From
The Member Secretary,
Madras Metropolitan
Development Authority,
Thalamuthu-Natarajan Building,
No.8, Gandhi Irwin Road,
MADRAS: 600 008

Lr.No. D2(L)/ 21753/89 dated 29/5-89

Sub: MMDA - Planning permission - ~~Layout~~
Sub-division in S.No. 34 of Puzhuthi vakkam
village - Approval of - Regarding

site plan (PROPOSED)

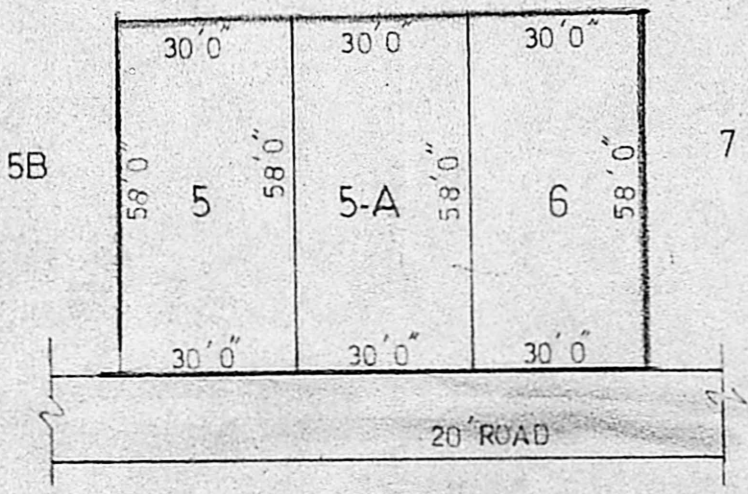
The proposal received in the reference cited for ~~laying~~
~~out of house sites/Sub-division of Plots~~ in Survey No. 34 of
~~Puzhuthi vakkam~~ village was examined
and layout has been revised to satisfy the Development Control Rule
requirements/~~Sub-division~~ and found approvable. ~~subject to the~~
~~condition that the revised plan number for the plots~~
5, 5A, 6 should be submitted by the applicant.

(X) you are requested to furnish revised
plan numbering the plots as 5, 5A & 6 before
submitting the DC charges.
